PLANNING | IOZ & LEVEL III SITE PLAN REVIEW

MMC 2400-space employee garage (ground level + 8 tiers) w/ 52 adjoining surface parking spaces (replacing 283 spaces in 'First Atlantic Lot') 190 St. John Street

DUMPSTER ENCLOSURE & PAD DETAIL
SCALE: N.T.S.

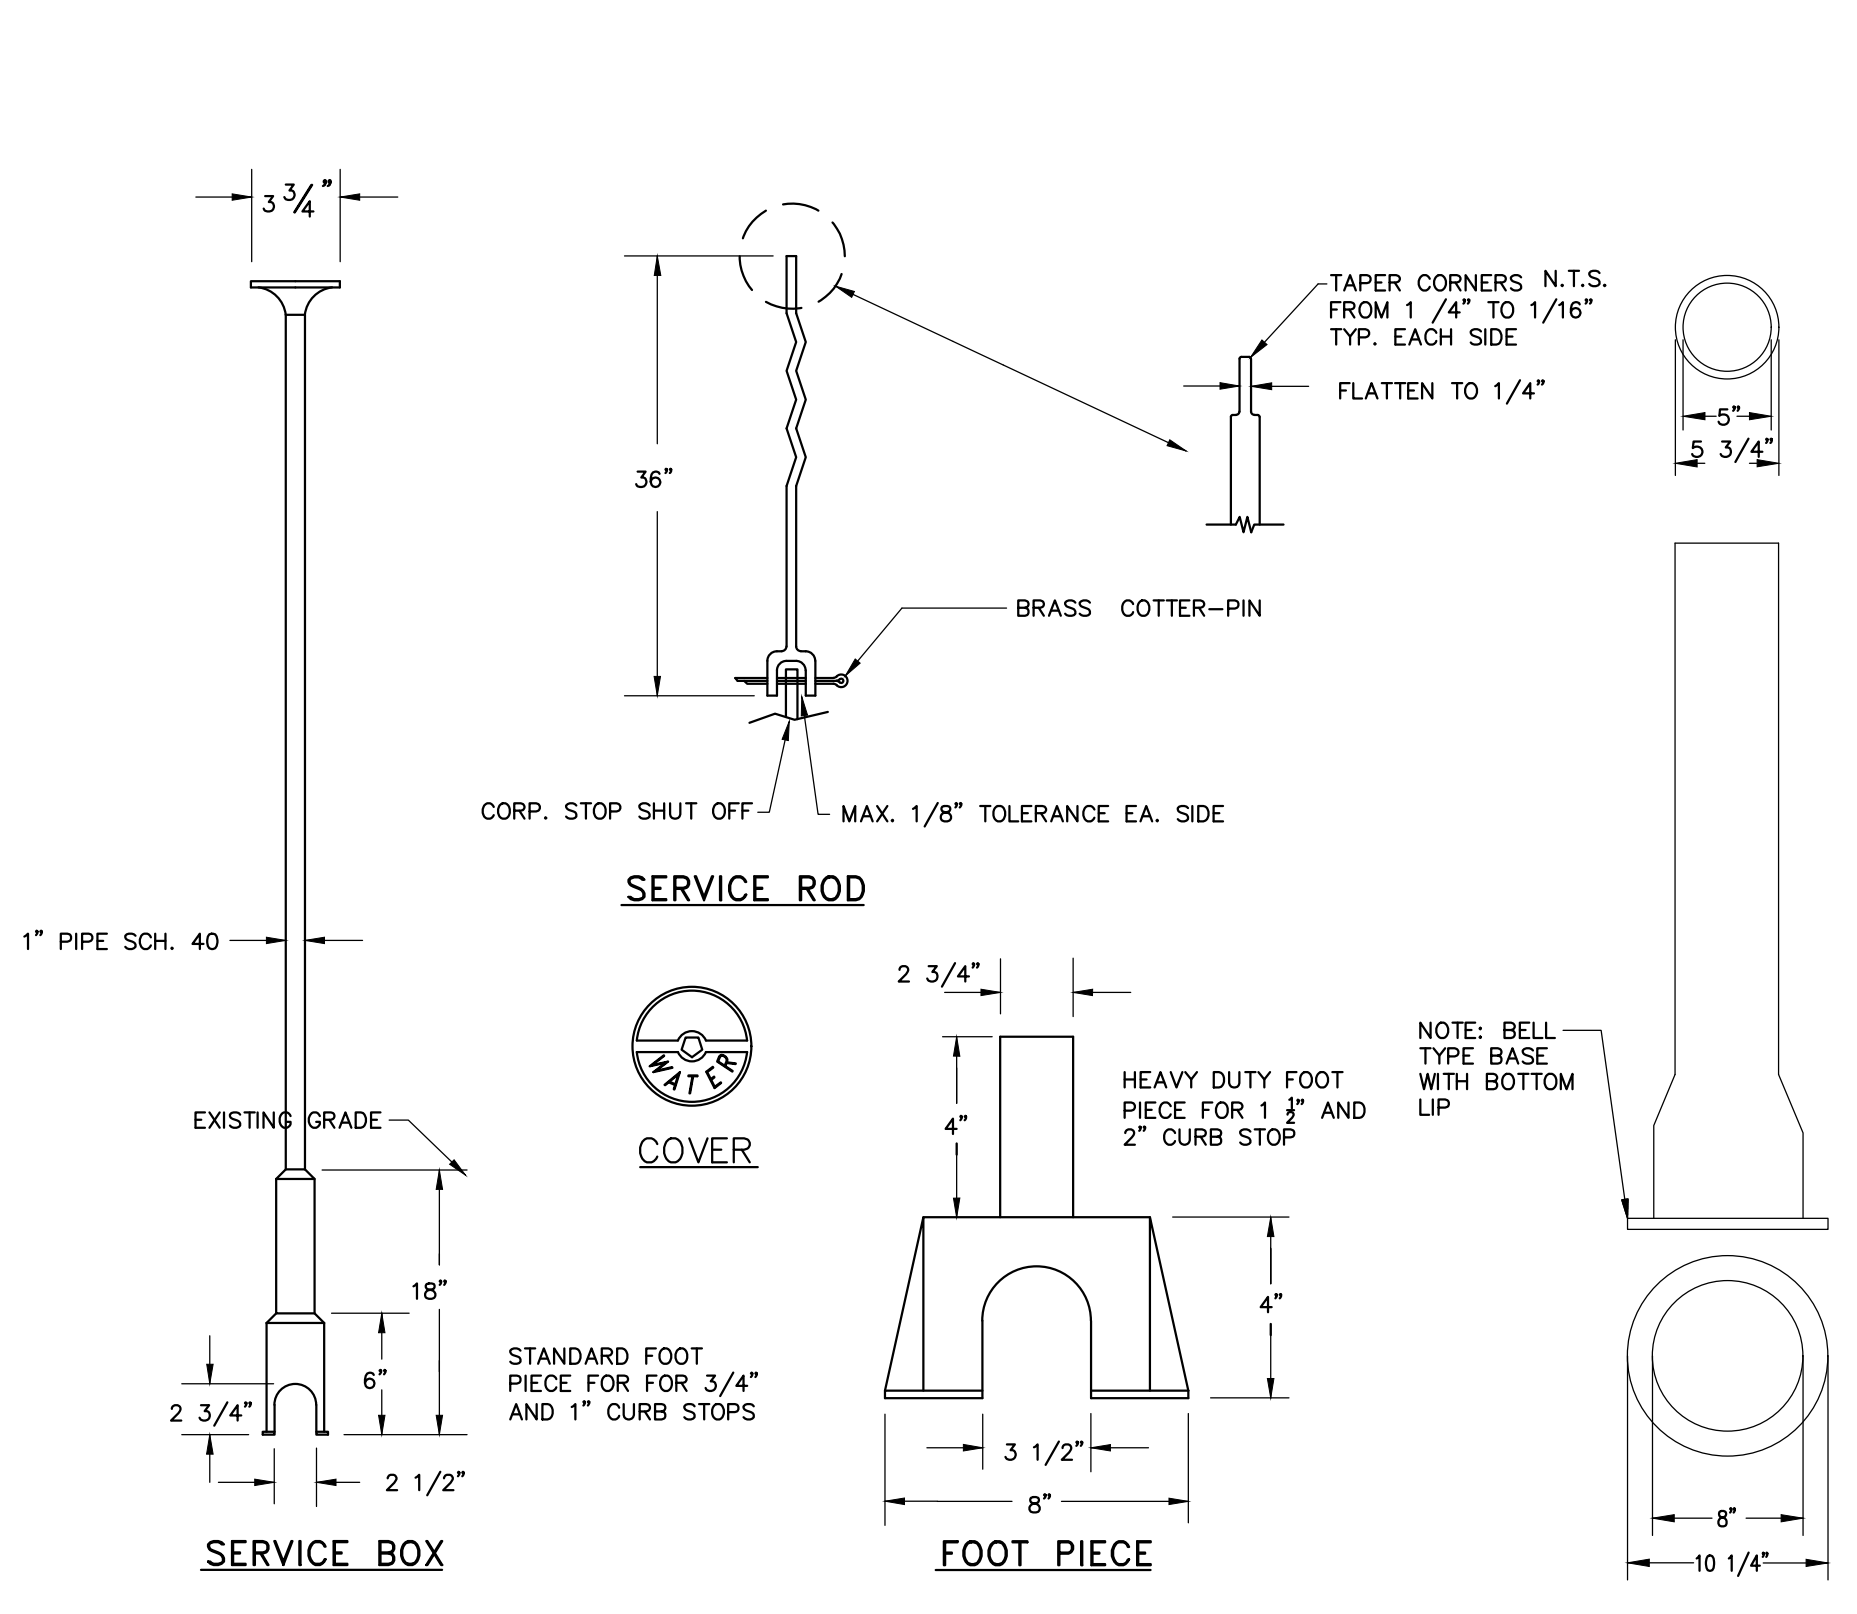
c. Availability and Adequate Capacity of Public Utilities	<ul style="list-style-type: none"> Need capacity to serve letters Revise dumpster enclosure to wood Provide capacity to serve letters upon receipt 	Need water capacity letter.
Site Design	a. Massing, Ventilation and Wind Impact	<ul style="list-style-type: none"> 	•

BIKE RACK DETAIL
N.T.S.

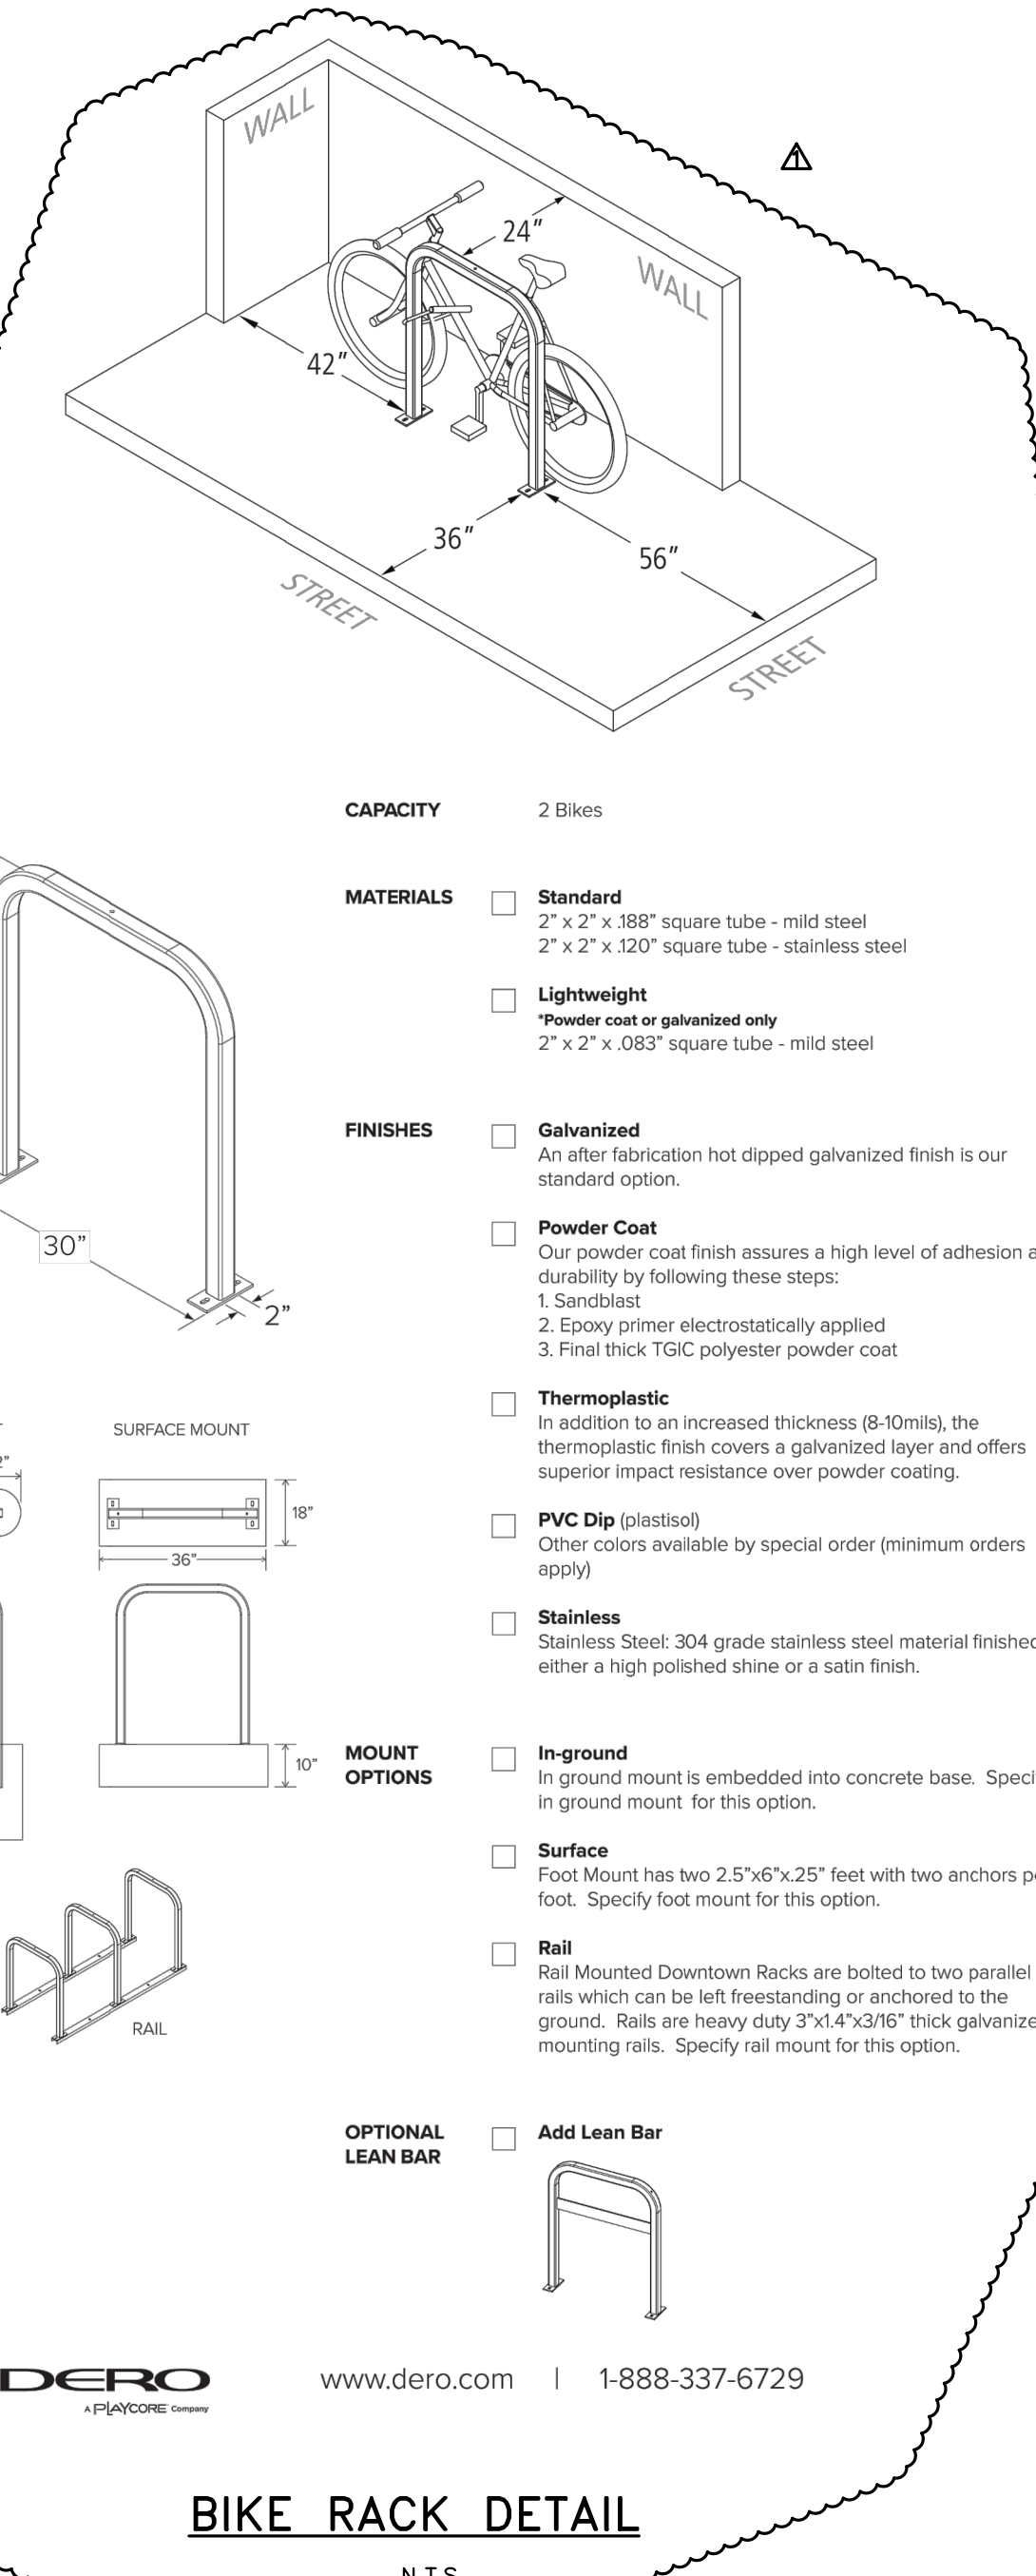
d. Parking	<ul style="list-style-type: none"> See notes on parking analysis above Support partial waiver on bike parking. However, bike parking location (in off corners of ground level of garage) should be reevaluated. Is there a more accessible location closer to the entrances? 	•
